From: Cleaver, Elizabeth [REDACTED]
Sent: 29 November 2019 19:44
To: Planning.Responses <Planning.Responses@arun.gov.uk>
Cc: Planning SE [REDACTED]
Subject: Highways England response: Y/102/19/DOC - Land to the South of Ford Lane, East of North End Road

Site: Land to the South of Ford Lane, East of North End Road, Yapton, BN18 0TN

Development: Approval of details reserved by condition imposed under ref APP/C3810/W/17/3170059 (Y/80/16/OUT) relating to Condition no 13 - highway works.

Planning Application No: Y/102/19/DOC

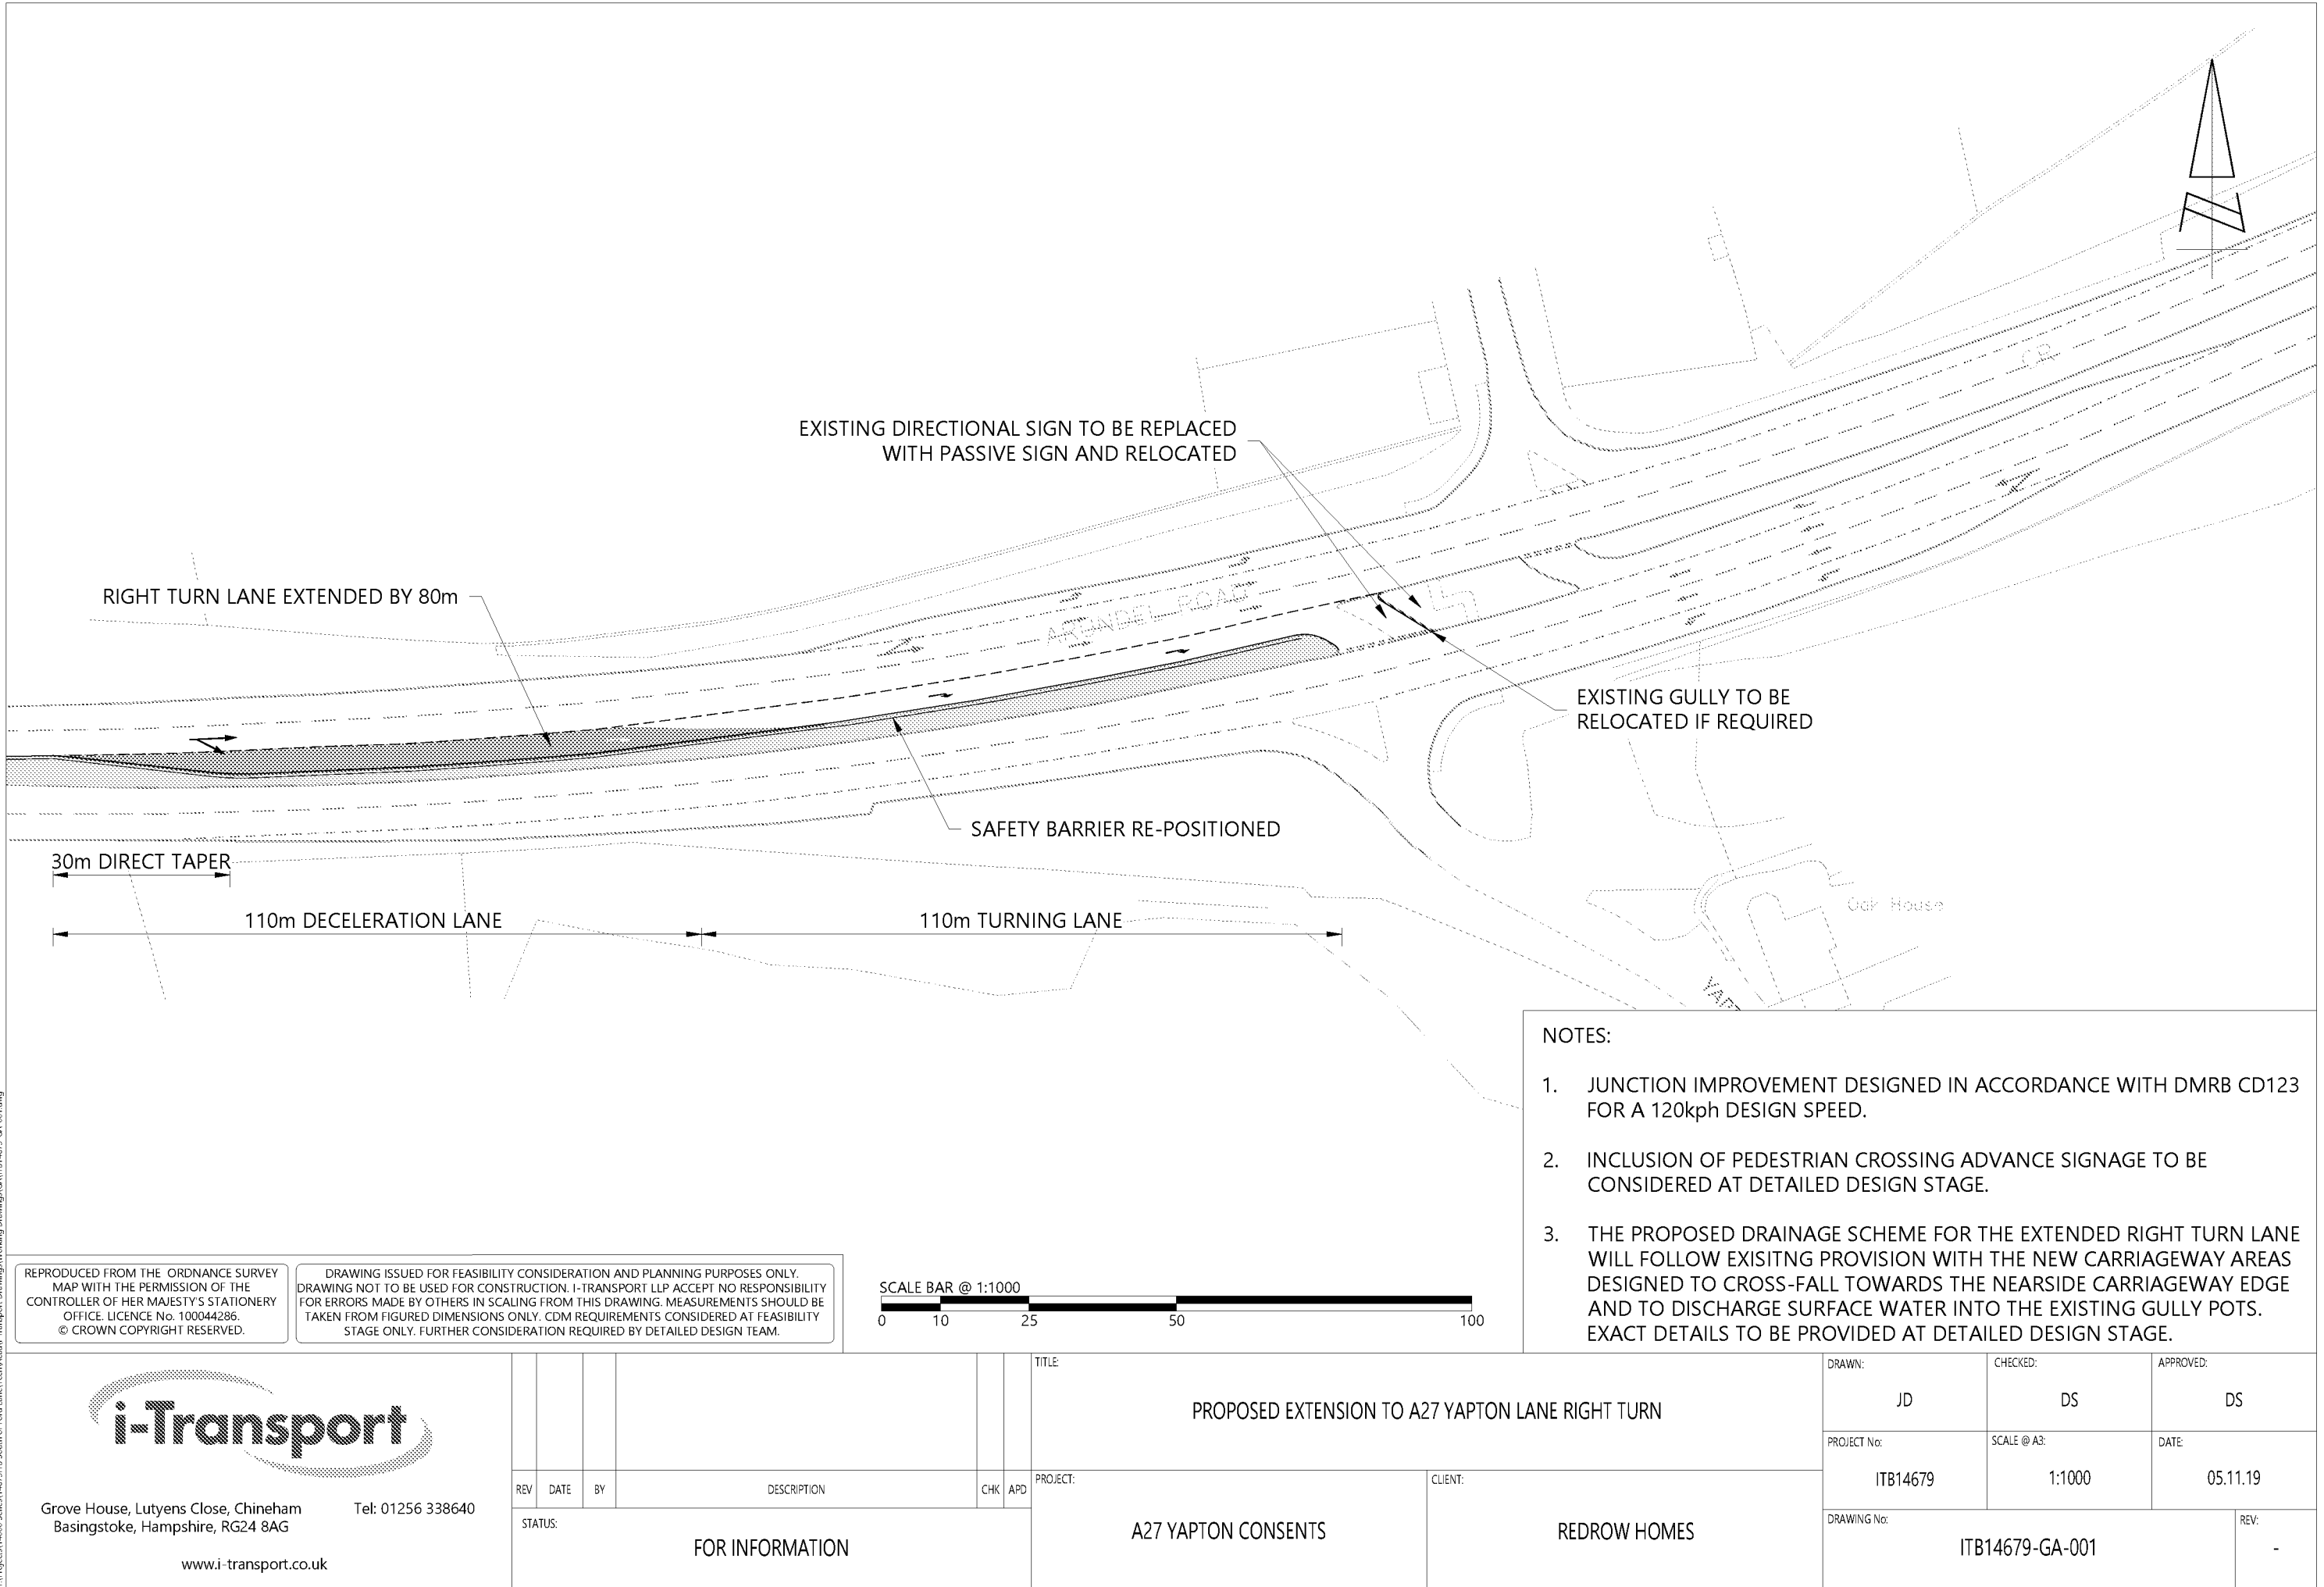
This application seeks Highways England's acceptance of the proposed junction improvement scheme in i-Transport's Drawing ITB14679-GA-001 in relation to the requirements of Condition 13 of planning permission APP/C3810/W/17/3170059 (Y/80/16/OUT). Condition 13 requires a detailed scheme of highways works, whereas drawing ITB14679-GA-001 is an outline design. We agree in principle to the outline design scheme in Drawing ITB14679-GA-001 as the basis for the detailed design scheme.

In view of the speed at which housing developments can be built and occupied, we recommend early contact with our third party project team (contact [REDACTED] so that the detailed design and section 278 improvement works can be progressed and concluded ahead of the 51st dwelling trigger point.
